9th September 2020

**Section 96A of the Town & Country Planning Act 1990 (as amended)
Town and Country Planning (Development Management Procedure) (England) Order 2015 (as amended) -
Article 10**

Application No: FP/153/20/NMA
Site Address: 28 Sea Drive Felpham PO22 7NE
Description of works: Non material amendment following grant of FP/205/18/HH for addition of window on east elevation.

PROPOSED EAST ELEVATION 1:100

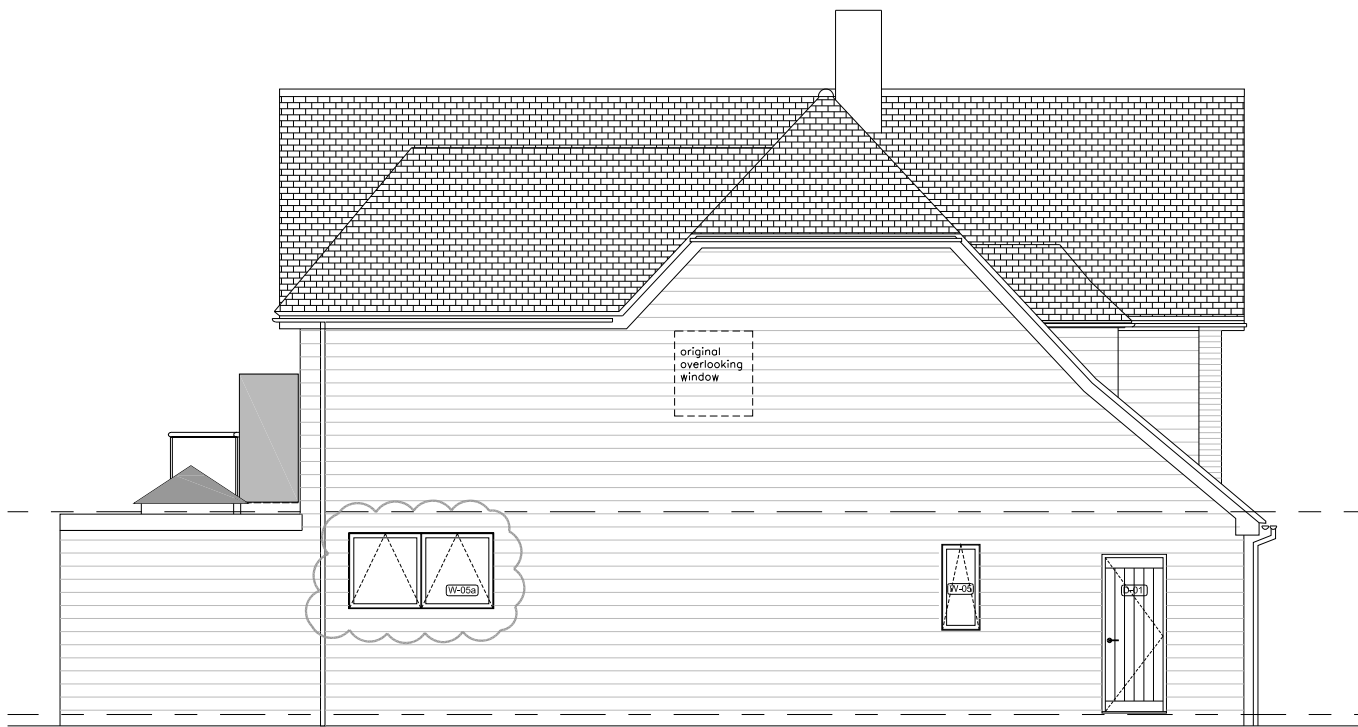
Objection - glass should be obscure.
